CITY OF ALBUQUERQUE

July 27, 2015

**Re: Alice Townhomes, 5900 Alice NE
Grading and Drainage Plan
Engineer's Stamp dated 9-16-14 (J18D043)
Certification Stamp Date: 07-16-15**

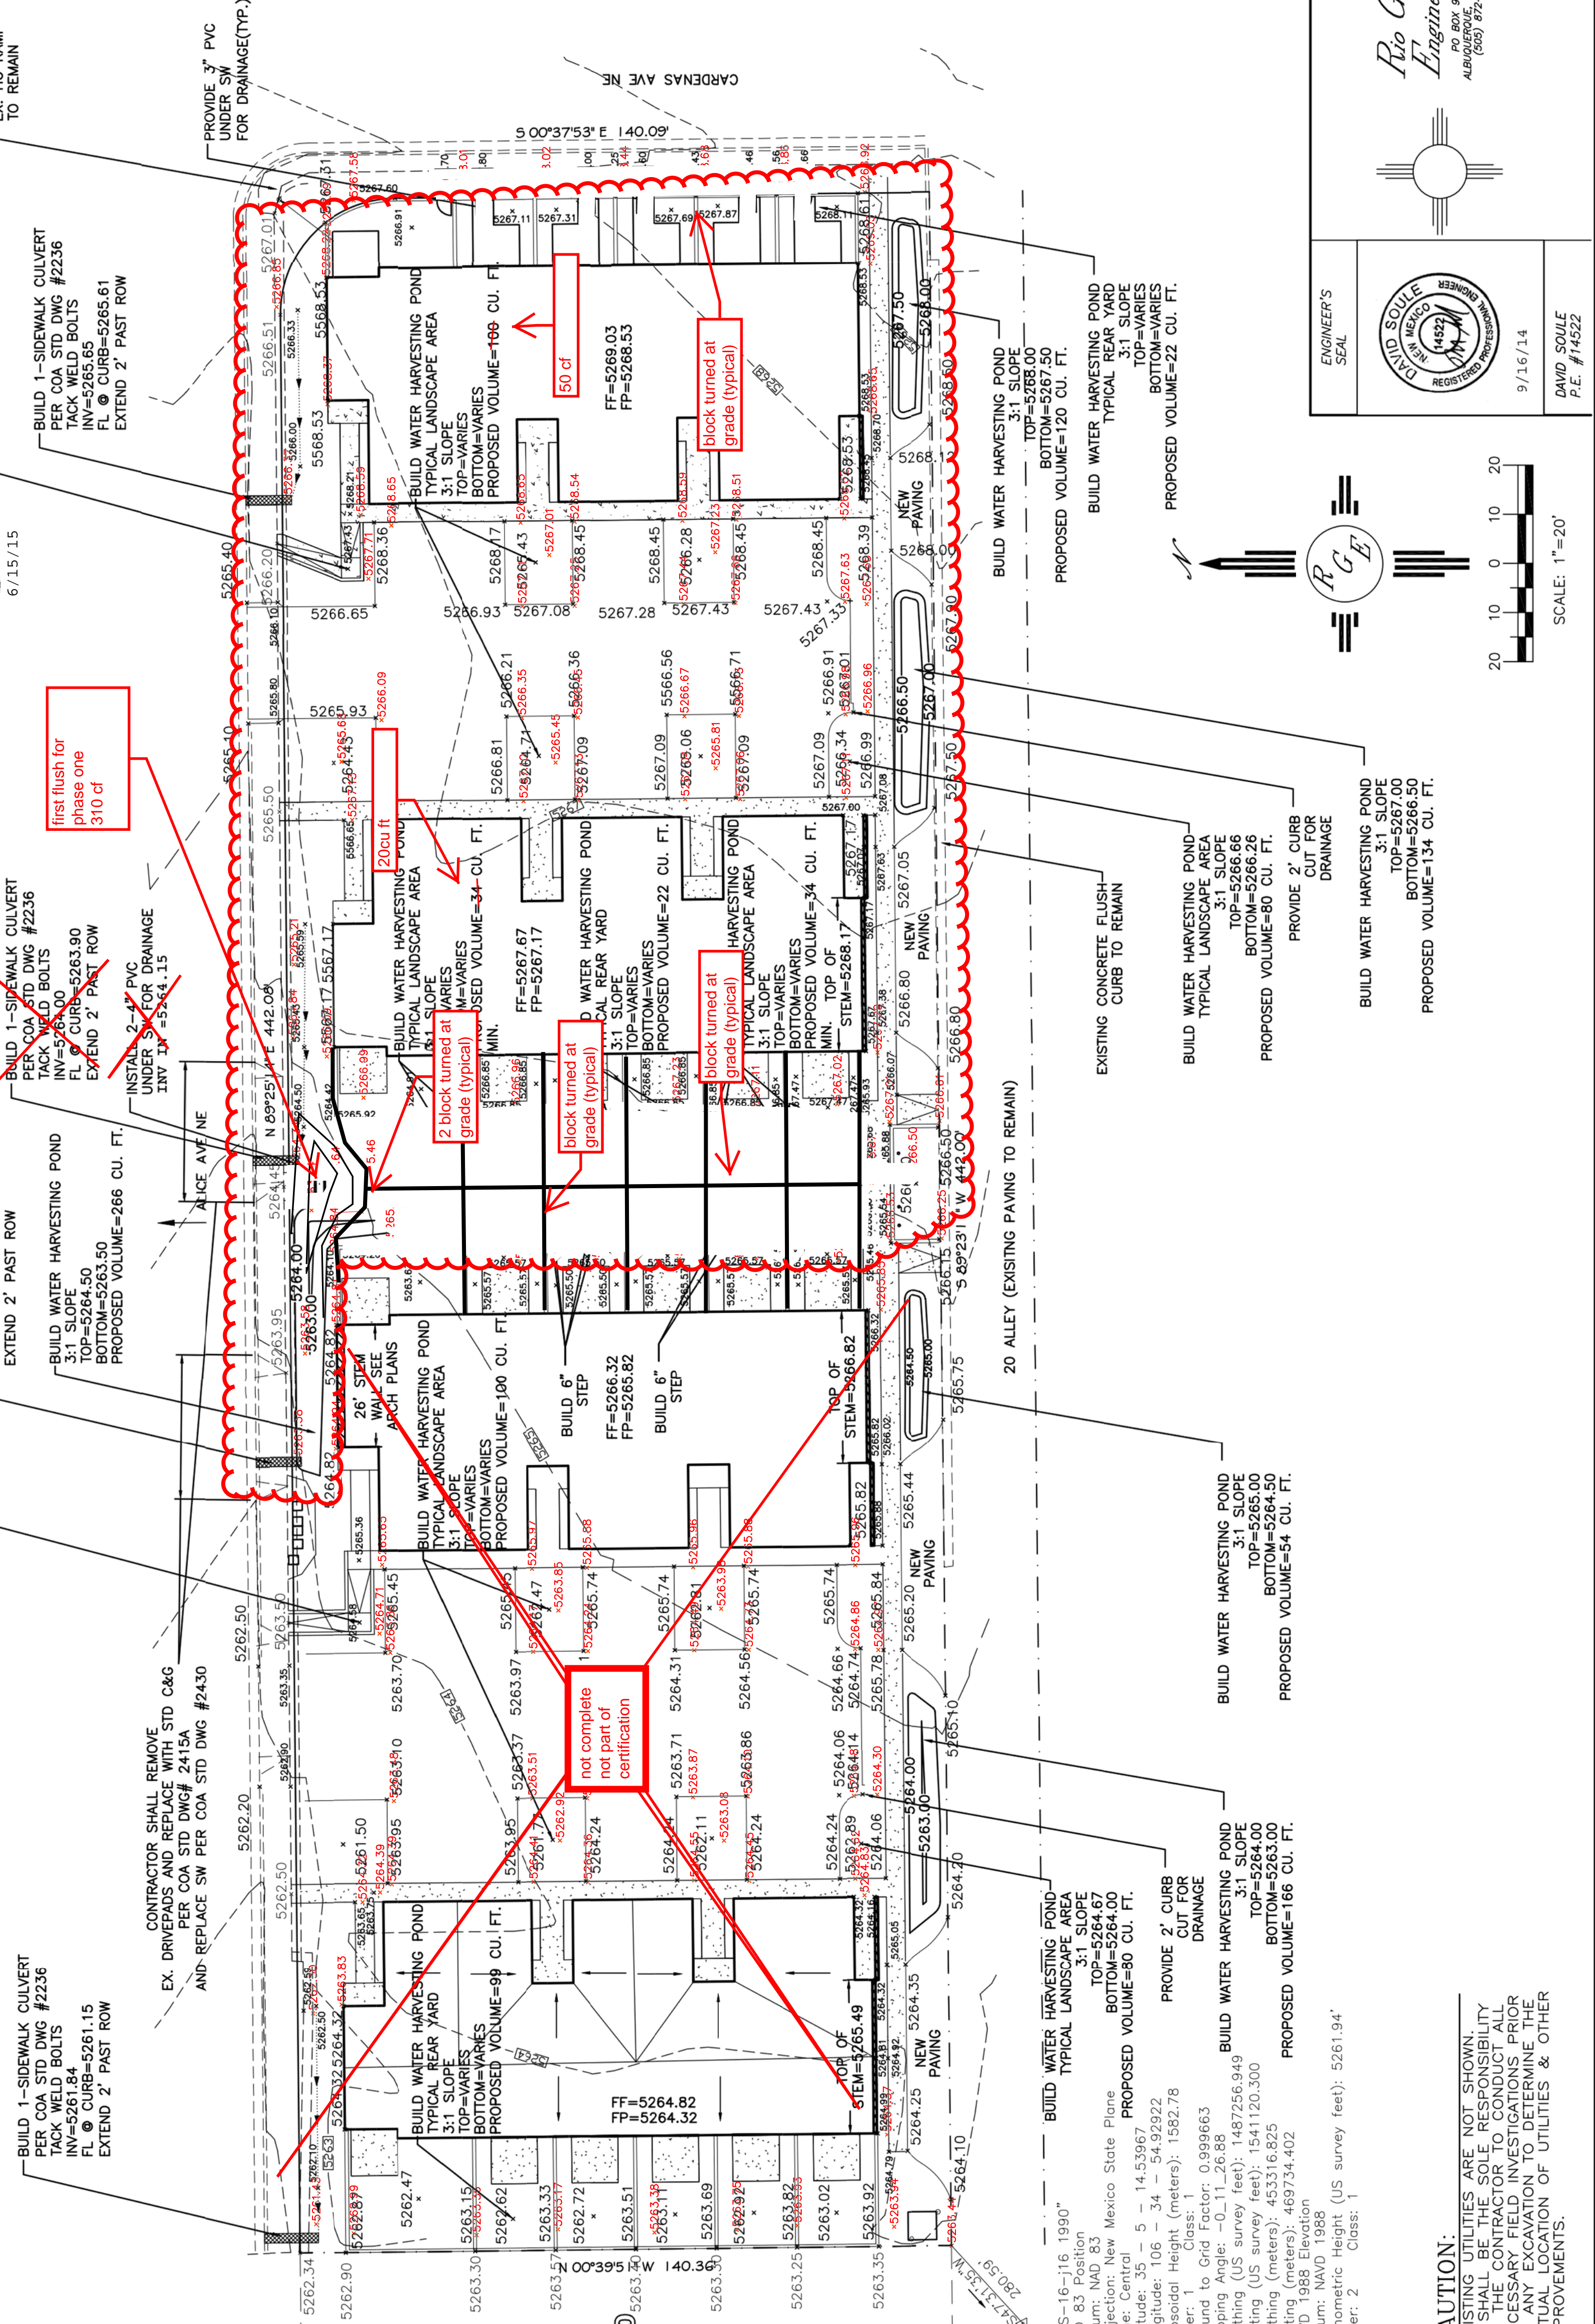
- No as-built elevations are provided for the ponds located to the south side of the buildings. **ALL EX PONDS SHOWN**
- It does not appear adequate ponding areas were created as it was shown on the grading plan (especially for the ponding area north of the building located in the middle of the project). **2077 PROVIDED 1297 REQ FOR FIRST FLUSH**
- Provide top and bottom areas/elevations for the pond including calculations to confirm the ponding volumes. **SPREADSHEET ATTACHED**
- An Administrative Amendment approval to the Site Plan for Building Permit is required for the changes behind the center buildings. **APPROVED AND SUBMITTED SEPERATELY**
